Recommendation Report for Planning Permission for Works or Extension to a Dwelling

REF NO: FP/107/19/HH

LOCATION: Cwm Ivy
12 Wansford Way
Felpham
PO22 7NL

PROPOSAL: First floor side extension and pitched roof to existing porch

PROPOSED ELEVATIONS

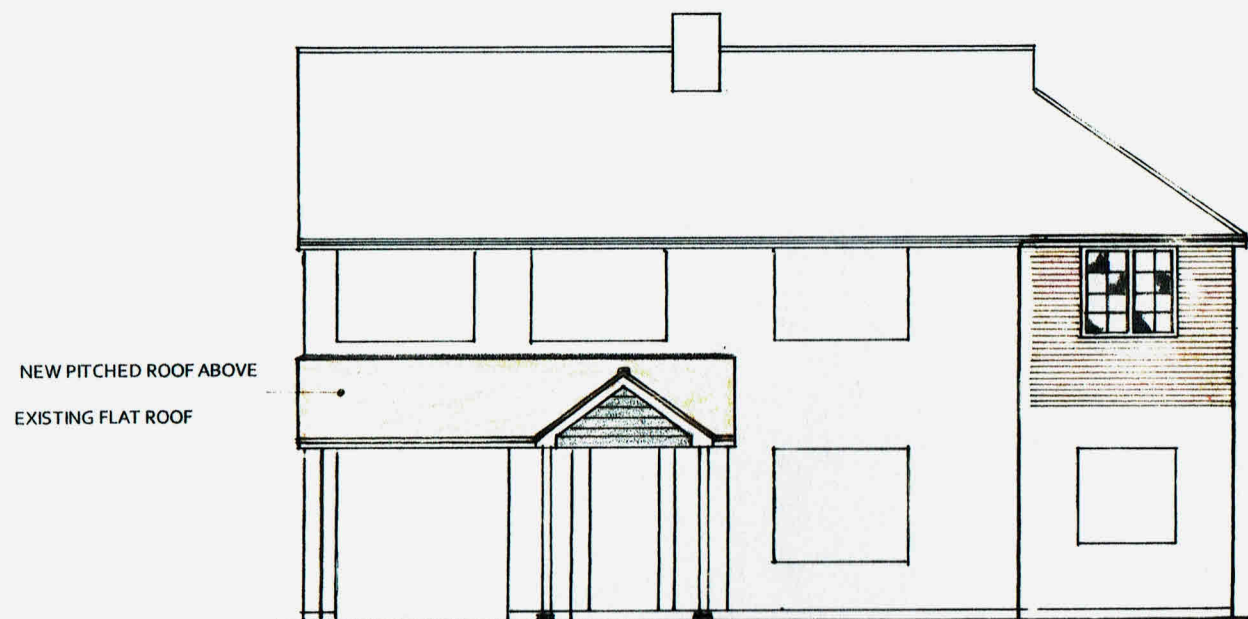
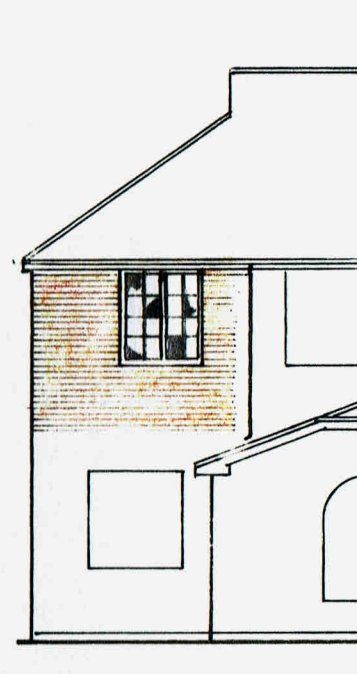
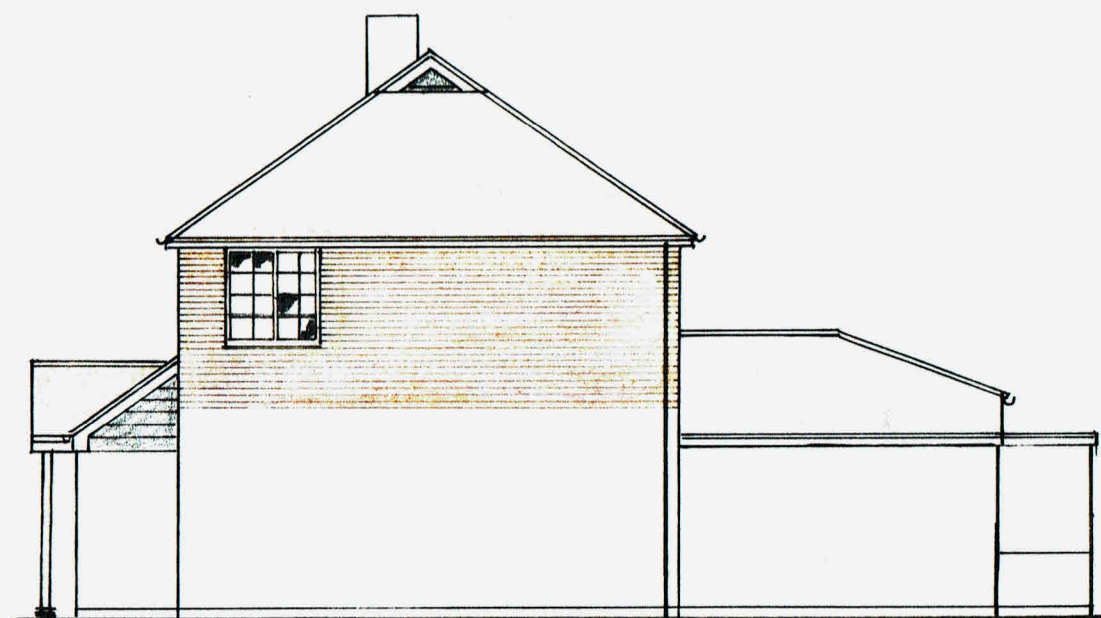
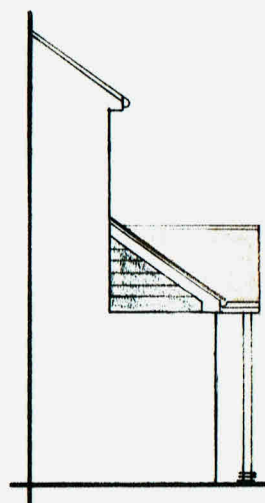
There is currently a single storey addition to the side of the dwelling and the proposal will construct a first floor. The roof will be hipped and sit below that of the host dwelling as not to appear unduly dominant.

There is an existing flat roof porch which will alter to form a lean to. A gable porch addition will also be constructed which will be open in appearance and extend around 0.5m beyond the existing porch. This is not beyond the established line of development and is not considered to appear overly dominant upon the principal elevation or street scene.

The materials will match that of the existing dwelling however the sides to the porch addition will be cladded. The neighbouring dwelling at No.10 is clad and therefore the material is not out of character for the area and is only used in a small amount.

The first floor will be situated above the existing side addition to the south at a width of 2.85m. It will have a height to match the existing eaves. The proposal will have a hipped roof therefore sloping away from the neighbouring property. There is a minimum of 1m retained to the boundary and due to the siting the development is not considered to appear overbearing or overshadowing upon neighbouring amenity.

There will be an additional window to the front elevation overlooking the street scene and an additional window to the side elevation facing south. The neighbouring dwelling has no openings to this elevation and as a result it is not considered to give rise to additional adverse overlooking.

There will be 1 additional window also to the first floor rear elevation. Whilst it serves a bathroom it will be conditioned to be obscured glazed as the neighbouring conservatory is constructed of glass and due to its siting it could give rise to adverse views and therefore this will ensure there is no unacceptable overlooking.

- 3 The window on the first floor east elevation of the building shall at all times be glazed with obscured glass and only openable at a high level, at least 1.7m above finished floor level.
